White Lodge
Hangleton Lane
Ferring
Worthing
West Sussex
BN12 6PP
17/07/2017

Ref. Planning application No.A/114/17/PL to widen Hangleton Lane on the west side to enable large vehicle access on the east side.

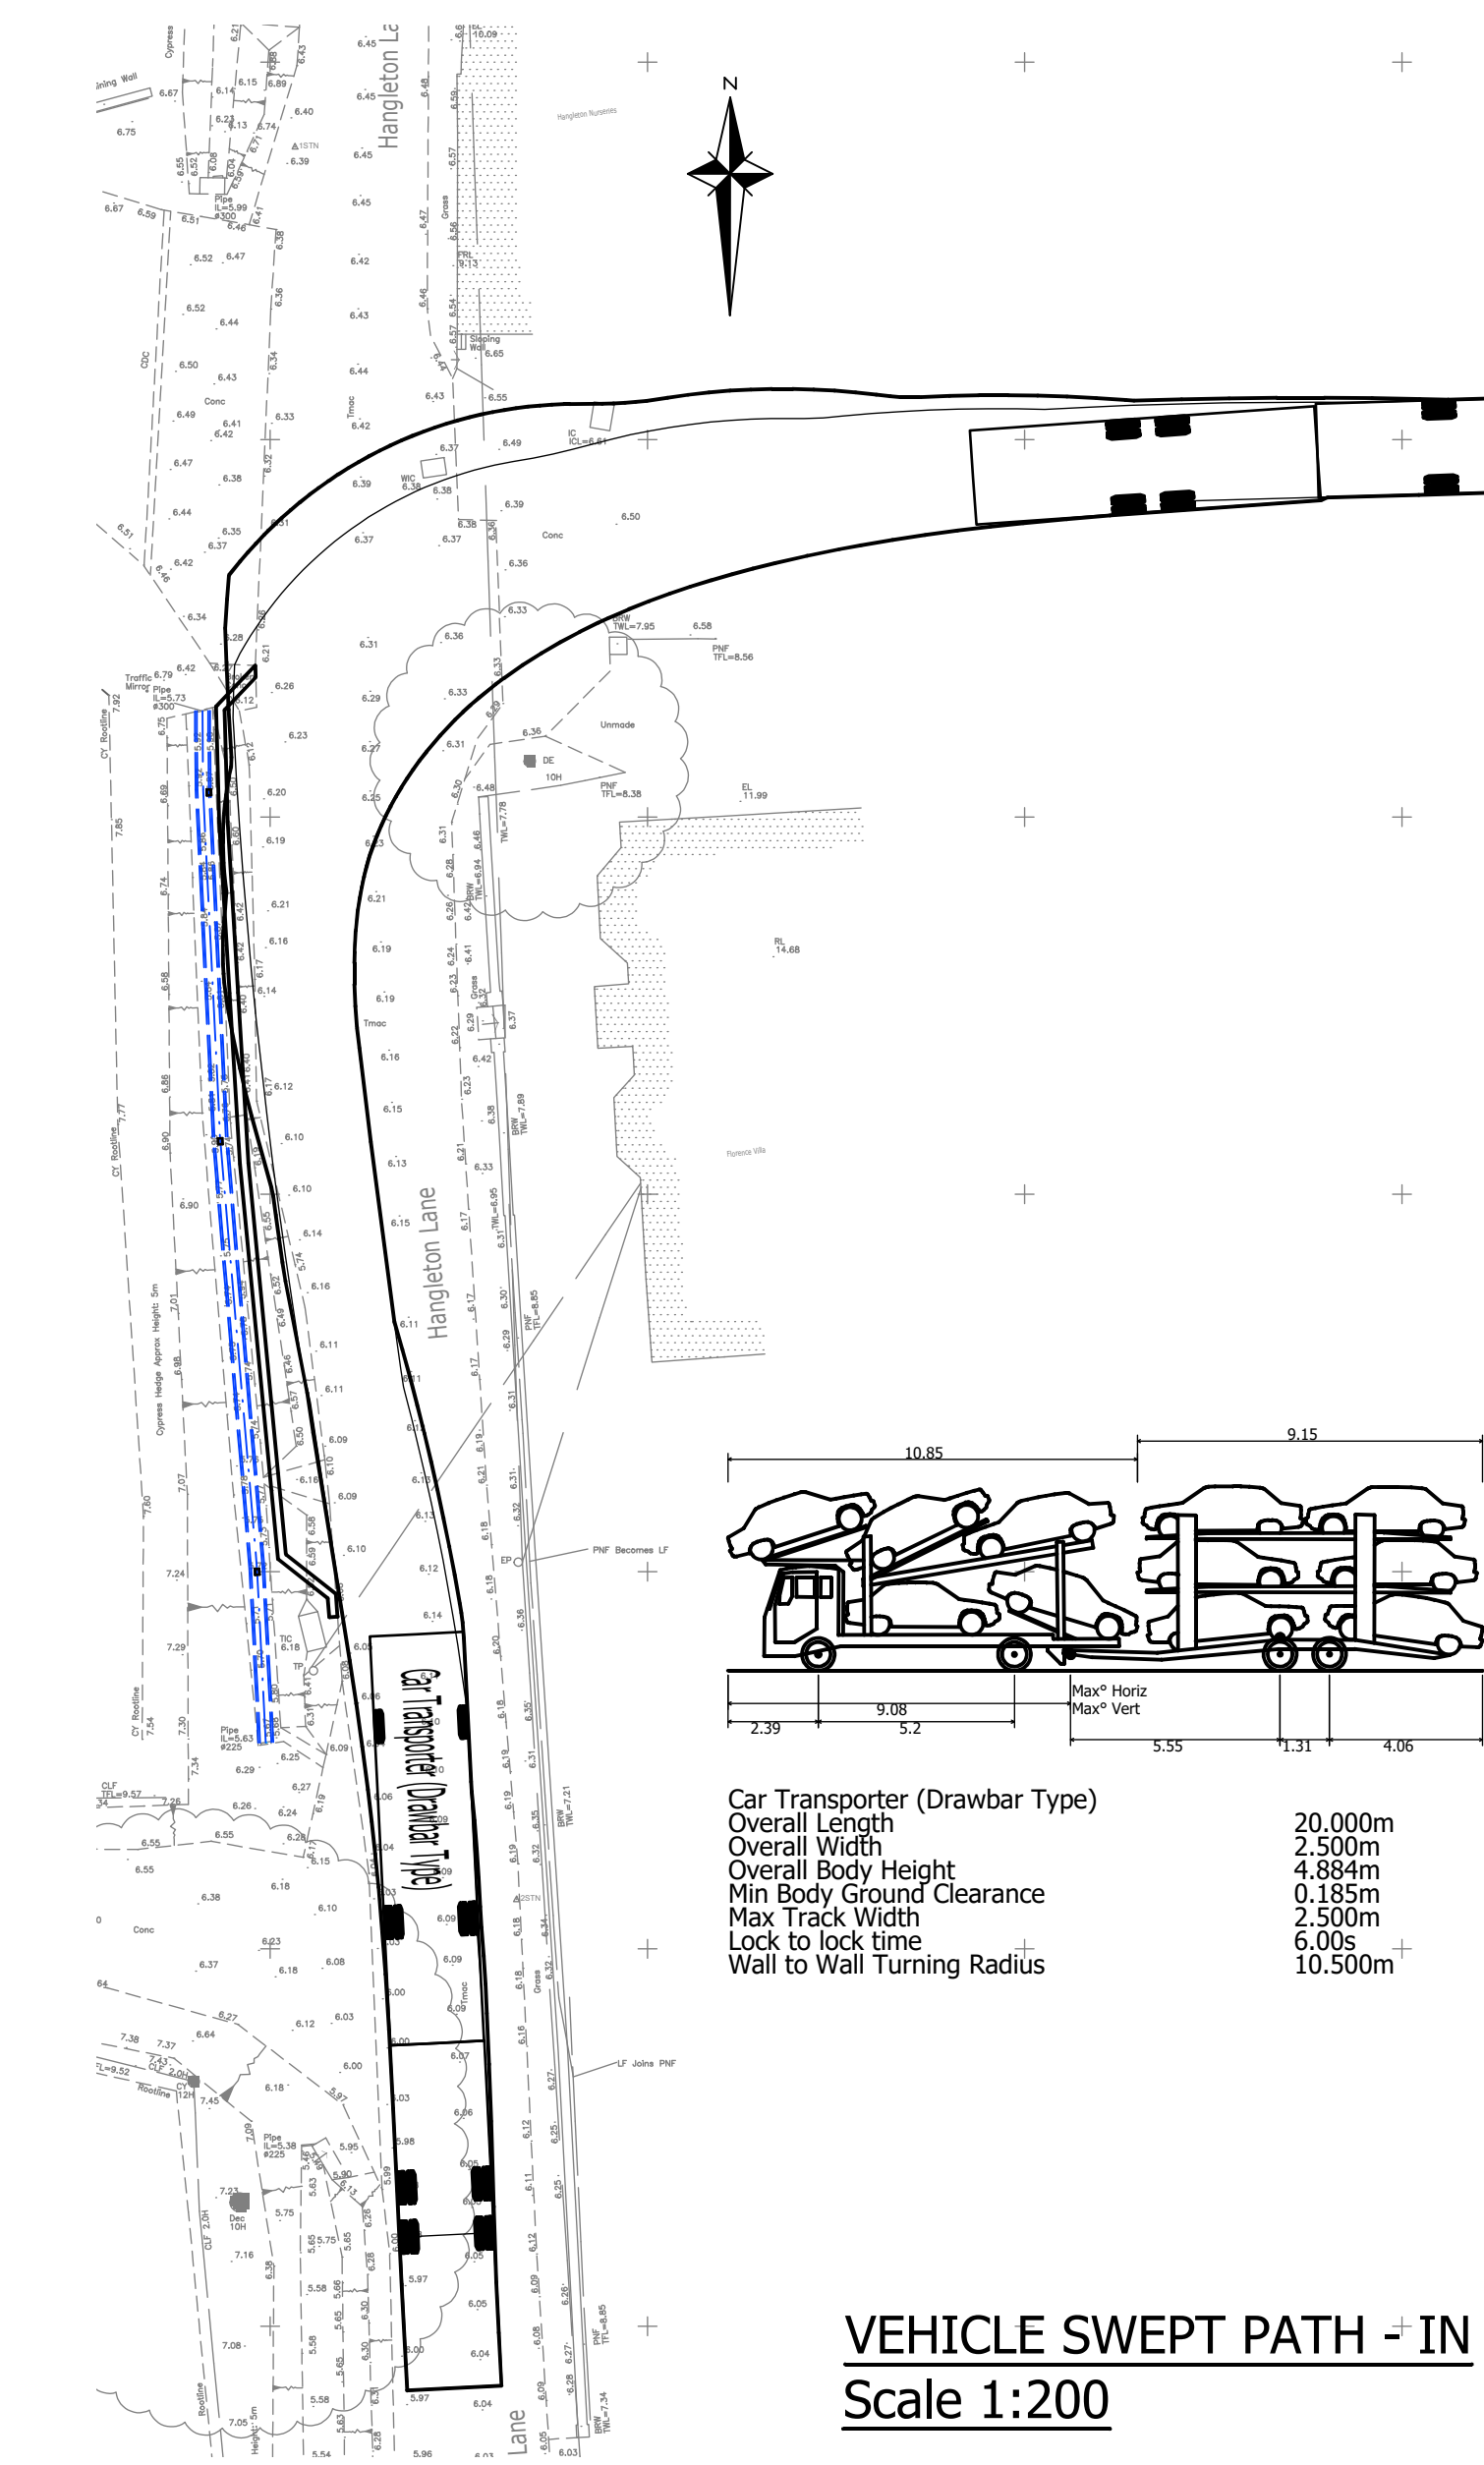
2. A large pull in on the west side of Hangleton Lane will only be used as a lay-by unless there is an entrance leading away from it which there won't be and why shouldn't it be used for parking (what is the difference between a pull in and a lay-by?)

If a vehicle is parked in this pull in we will be back to square one or even worse, If a transporter turns into Hangleton Lane to access this site and a vehicle is using it for parking where can the transporter go? it cant turn around in the Lane or reverse onto the A259 dual carriageway, it will just block the lane until the driver of the said vehicle is found!

3. Even with this pull in transporters will still have to use part of Cobbins Nursery roadway to get a hard right turn, has Mr Lisher the owner of Cobbins Nursery been consulted and given his permission because without this extra bit of Cobbins entrance road vehicles will still not be able to access Yeomans storage site.

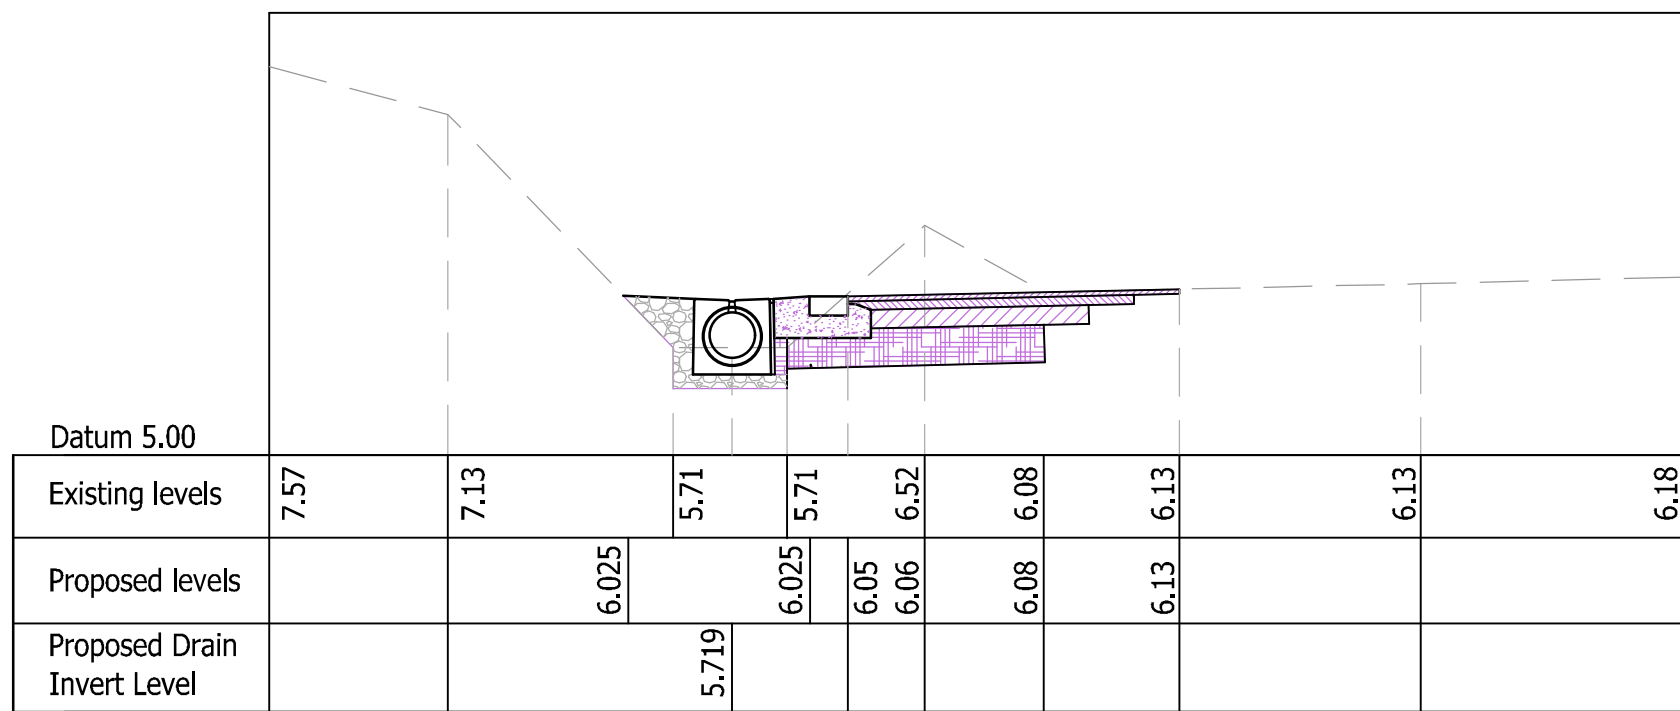
5. ADC are well aware we have a flooding problem at the bottom of the lane which they do nothing about! If this widening is allowed the ditch water will obviously be ducted under the concrete, this will be a considerable length which will be uncleanable, when it has to be cleaned who would pay? ADC / the taxpayer / Cobbins Nursery or (JUST LEAVE IT BLOCKED) as will happen with the amount of silt and debris washed down from Highdown hill this ducting can be blocked even after one heavy downpour, all this just to please Yeomans
